Our ref: DOC20/545309

Response to Submission comments for Moriah College Redevelopment (SSD-10352)

STAGE 1

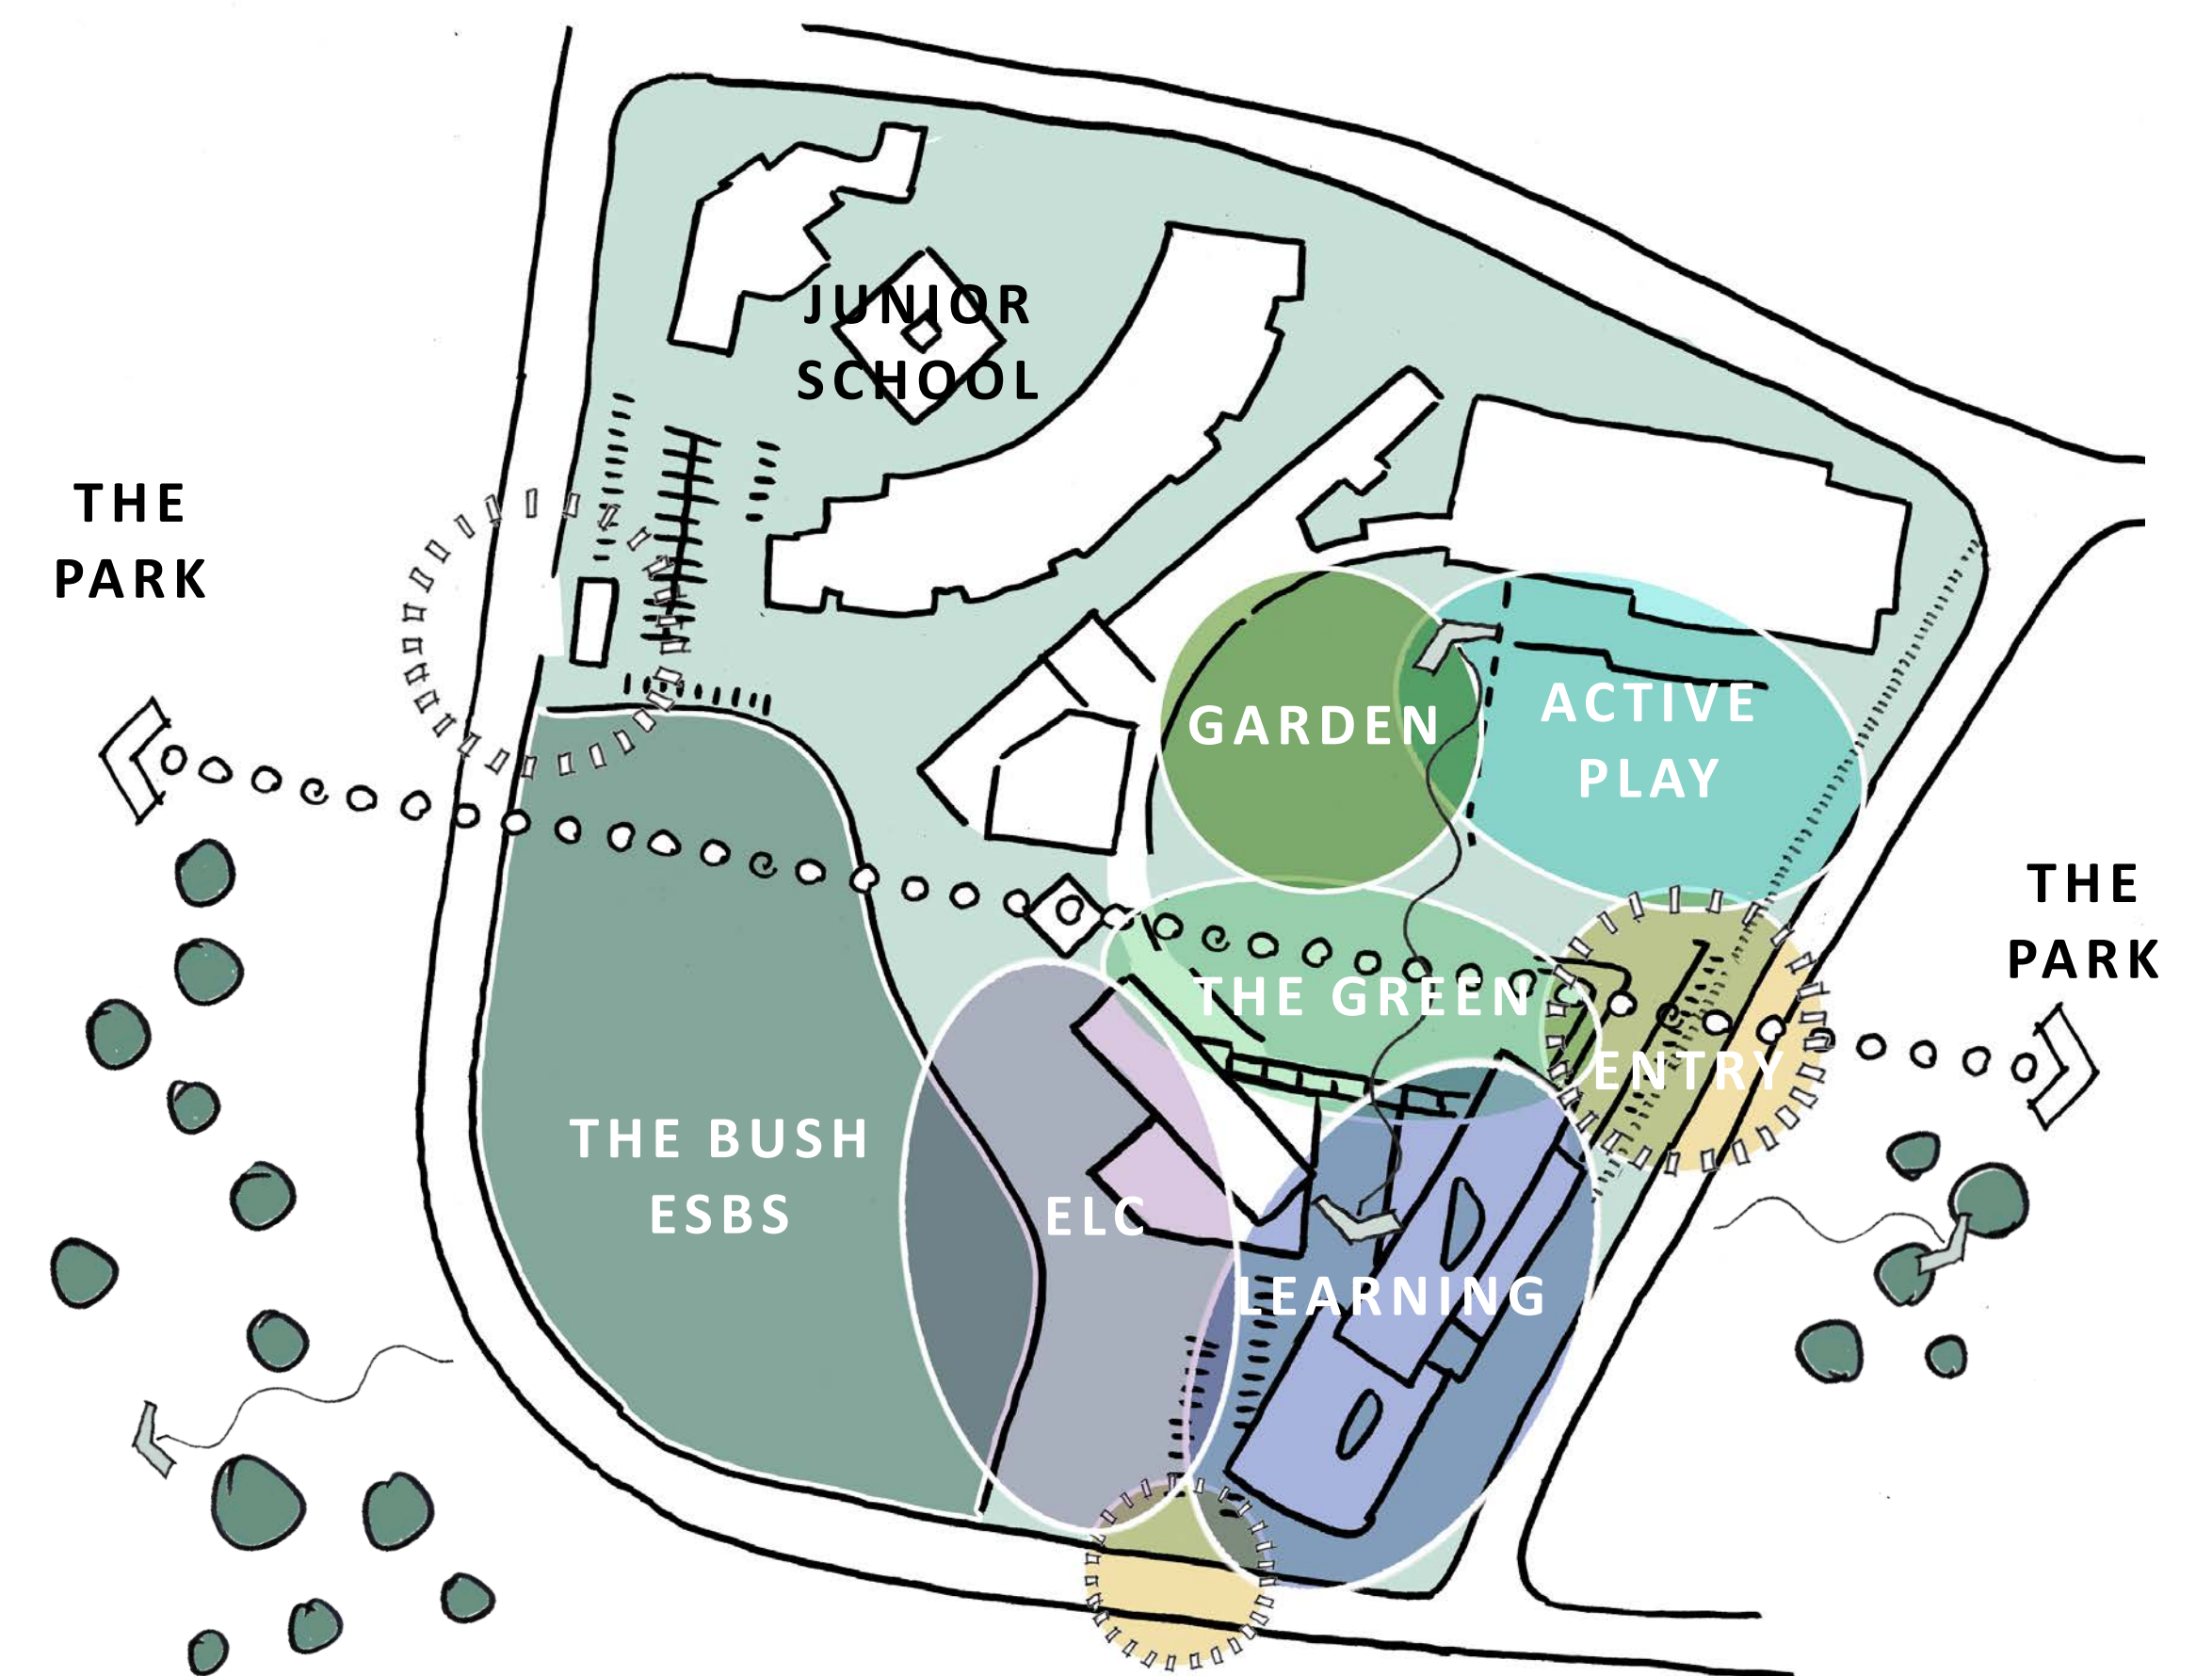
- The amended Landscape Drawings submitted as Appendix B incorporate perimeter landscape treatment and plantation to Baronga Avenue and is considered acceptable to mitigate visual impacts. It is noted, that the landscape proposal submitted during EIS stage indicated that the York Street frontage of the site would be treated with a canopy cover. These updated drawings, however, do not include perimeter treatment along York Street frontage. It is recommended that the perimeter plantation extend to York Street as well as Baronga Avenue, to improve the visual amenity of the subject area and surrounding locality.
